From: Peter Cleveland
Sent: 15 September 2011 16:23
To: 'sabine kunze'
Subject: 52 East Front Road

Further to our meeting on Tuesday I have been able to discuss the extensions at the above site with Nik Antoniou (Head of Development Control) and we have discussed the points you raised and looked through the plans which identify the different schemes and of most importance the revised scheme.

For	Date	Dwg by	Revision
Mr and Mrs Evers	24.05.2011	sk	C
Title	Scale	Project no	Dwg no
PROPOSED LAYOUT, ELEVATIONS AND SECTION A-A	1:50	126	P2

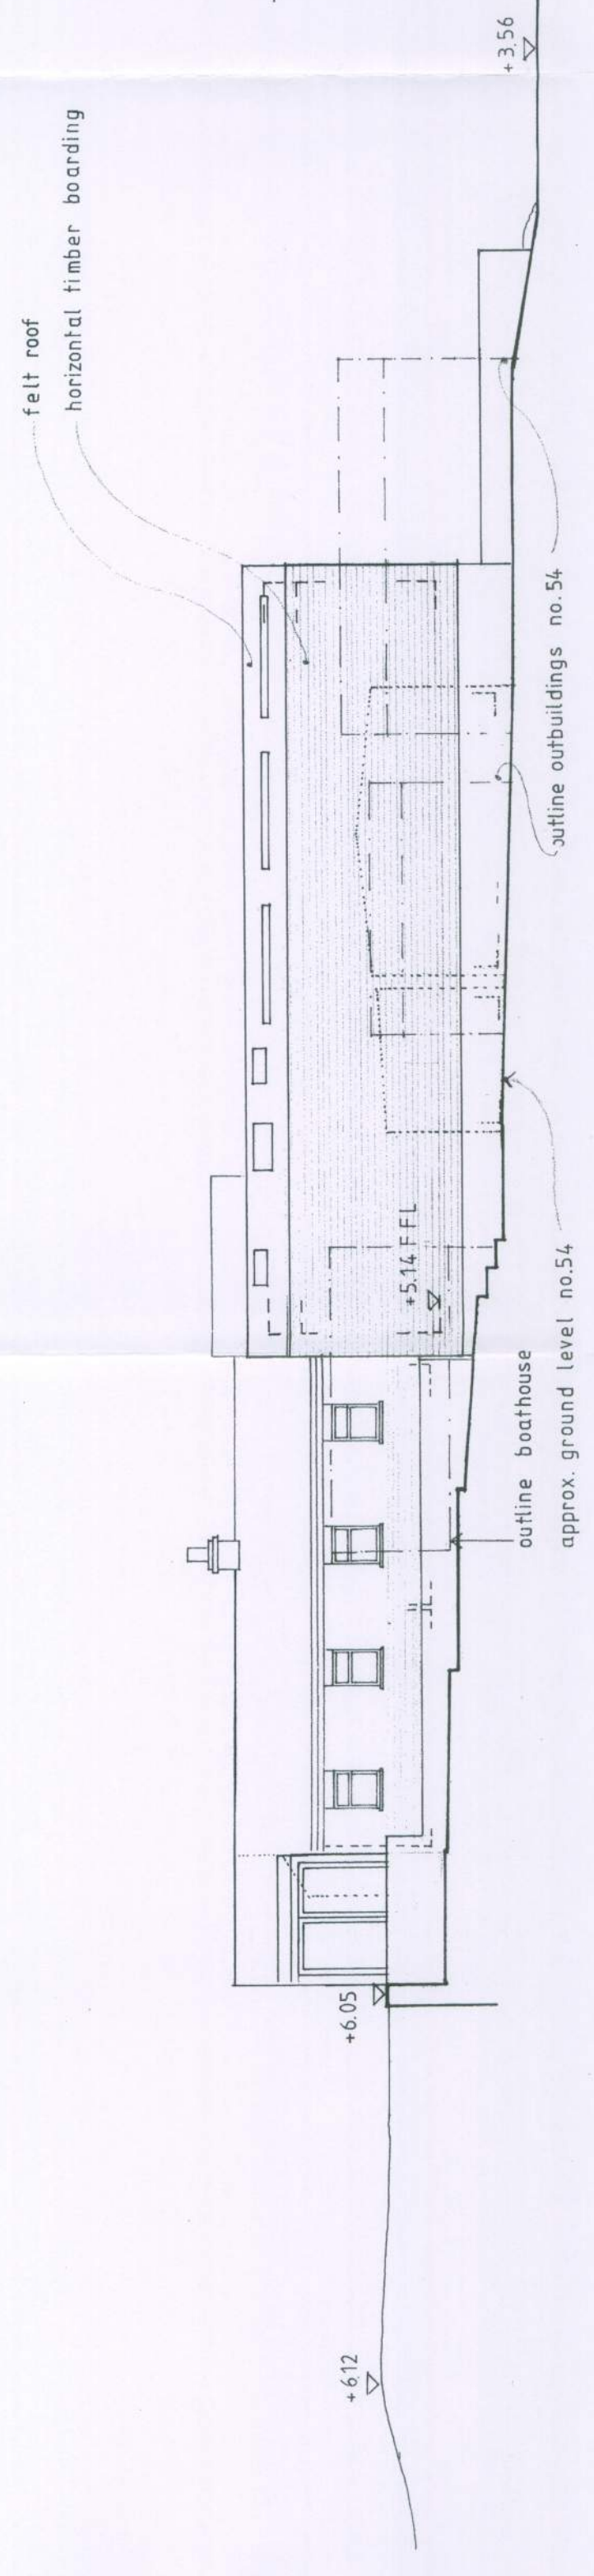
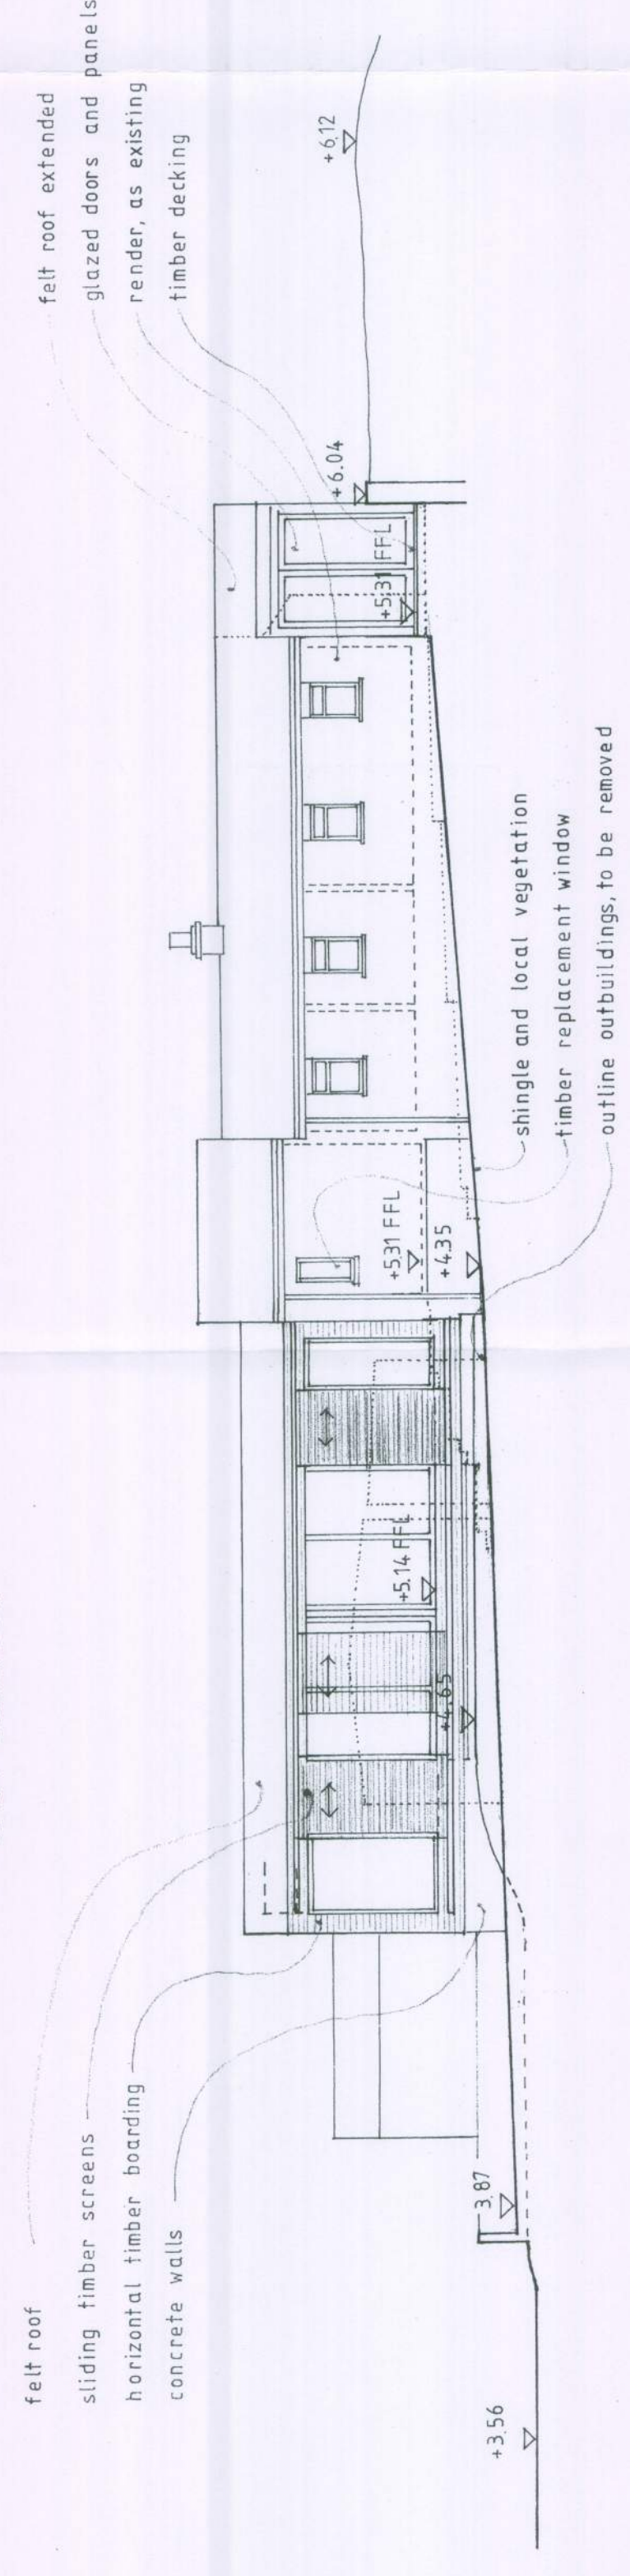
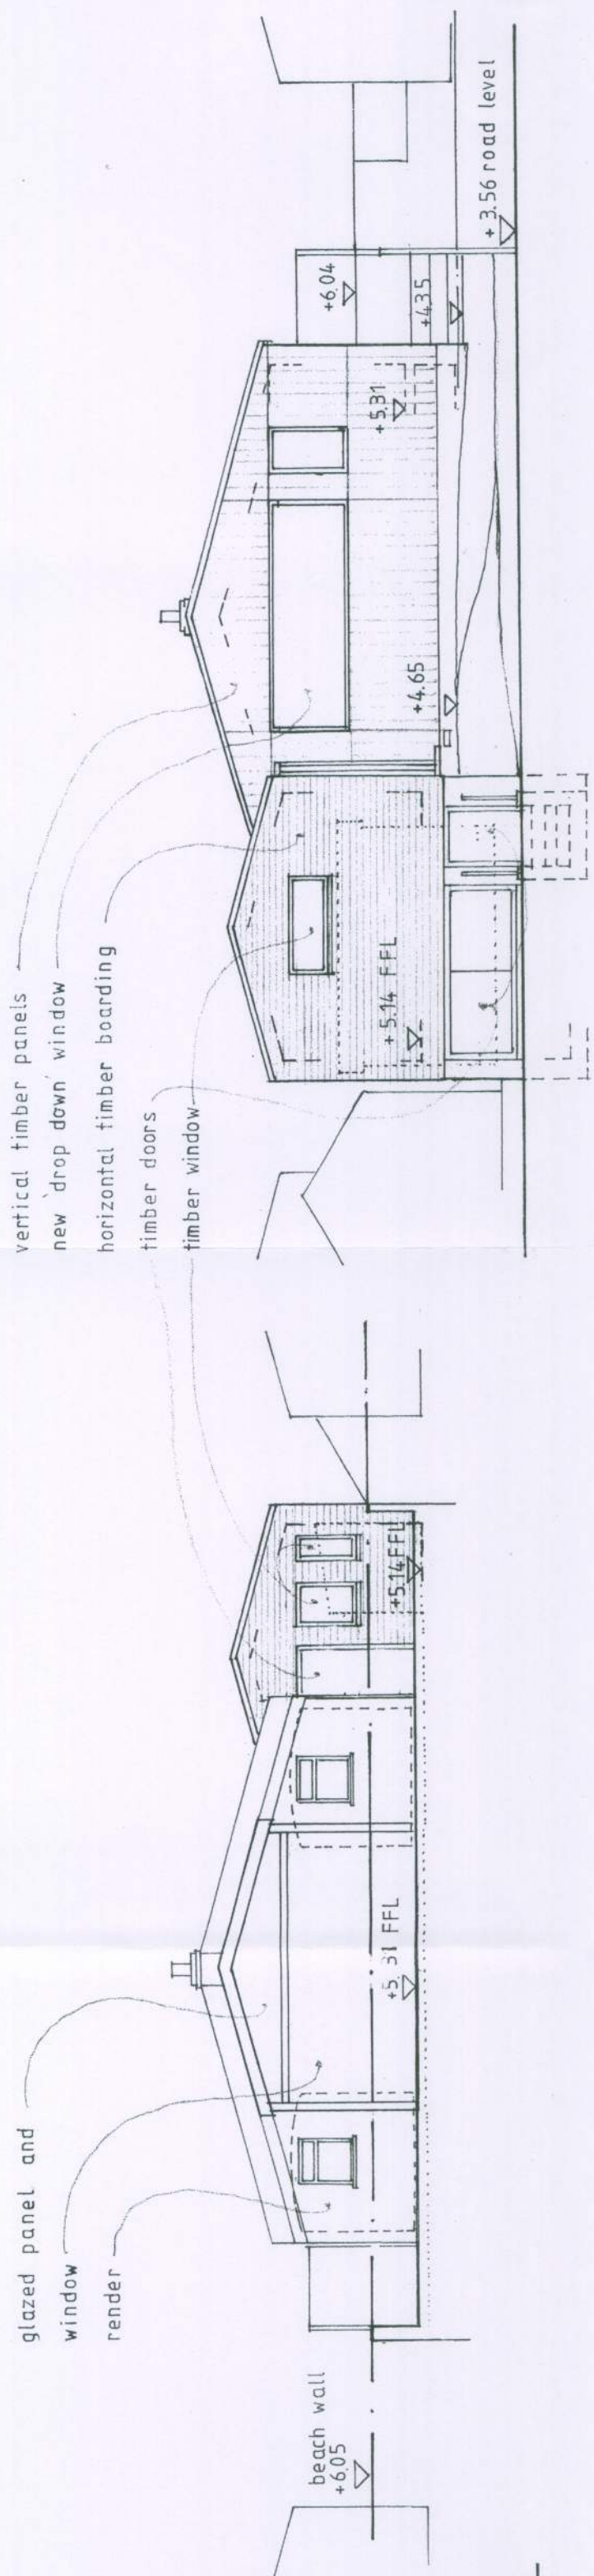
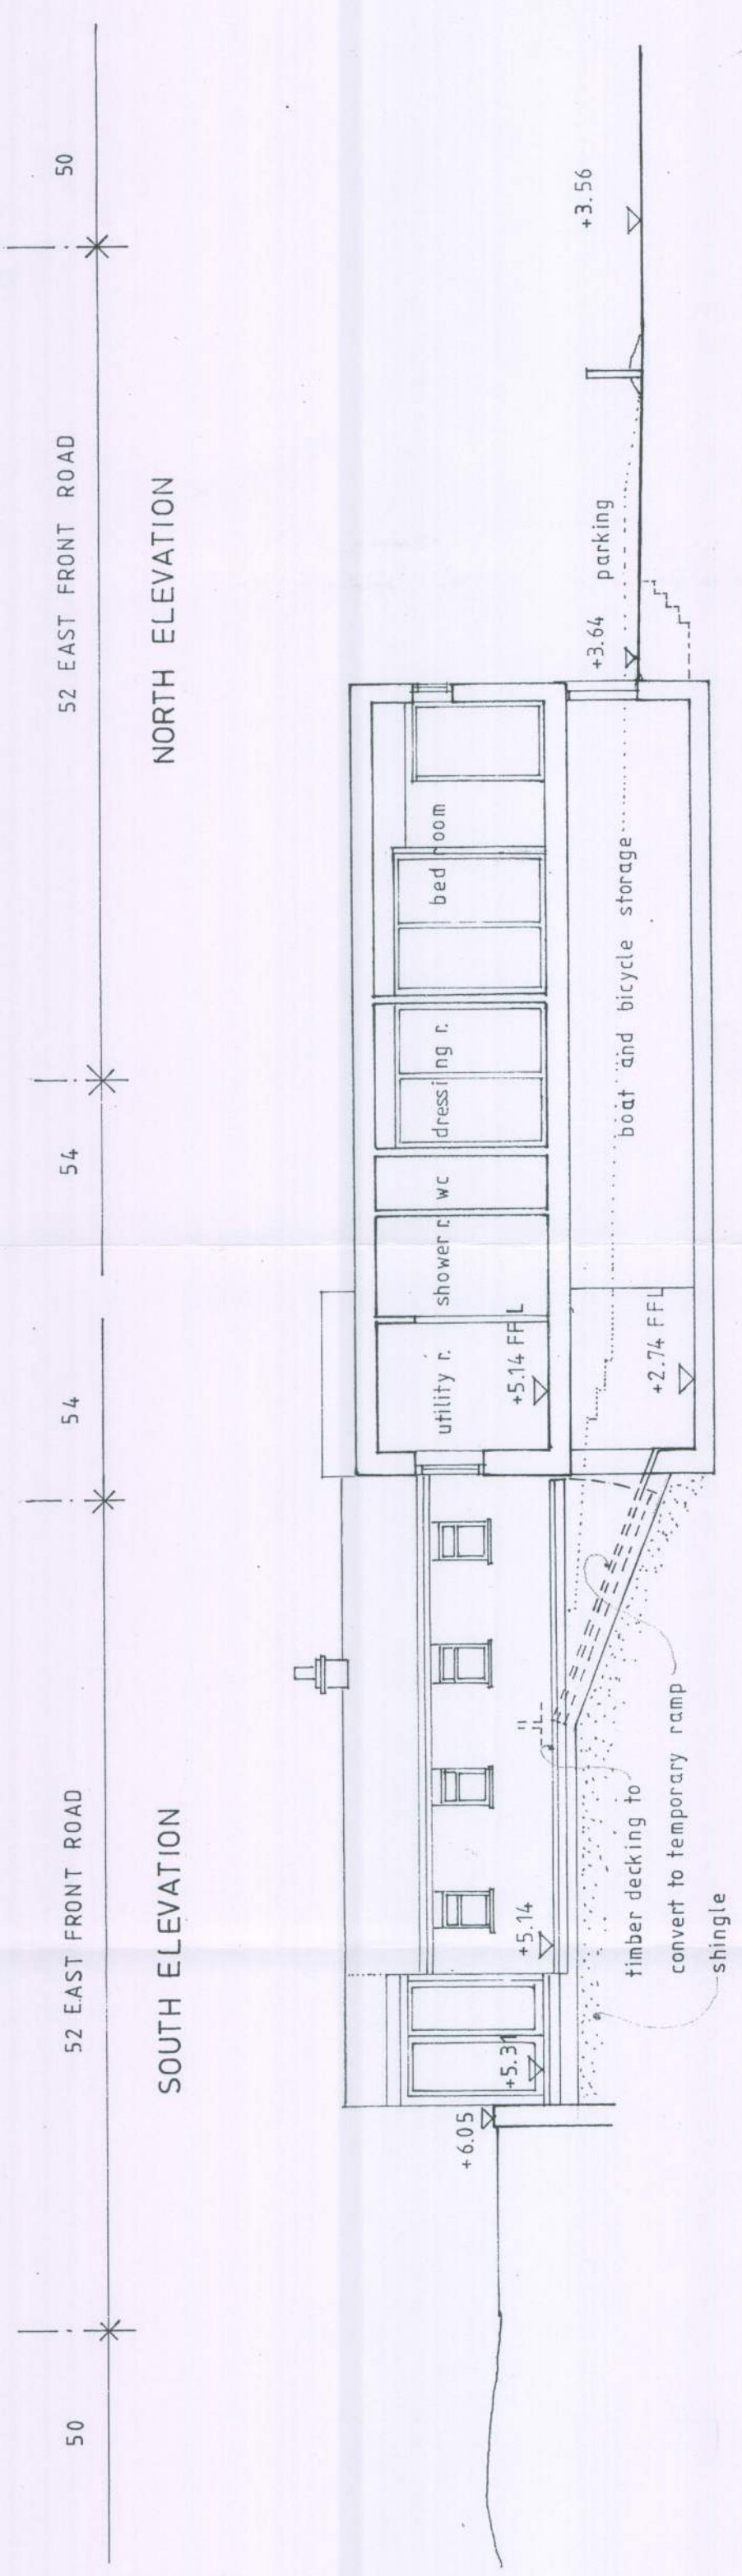
He has agreed with both Jon Parsons and myself that the proposed amendment with the reduction to roof height, width, roof lights etc would be an acceptable scheme to overcome the previous reasons for refusal. As such we suggest that an amended planning application could be submitted to be reconsidered.
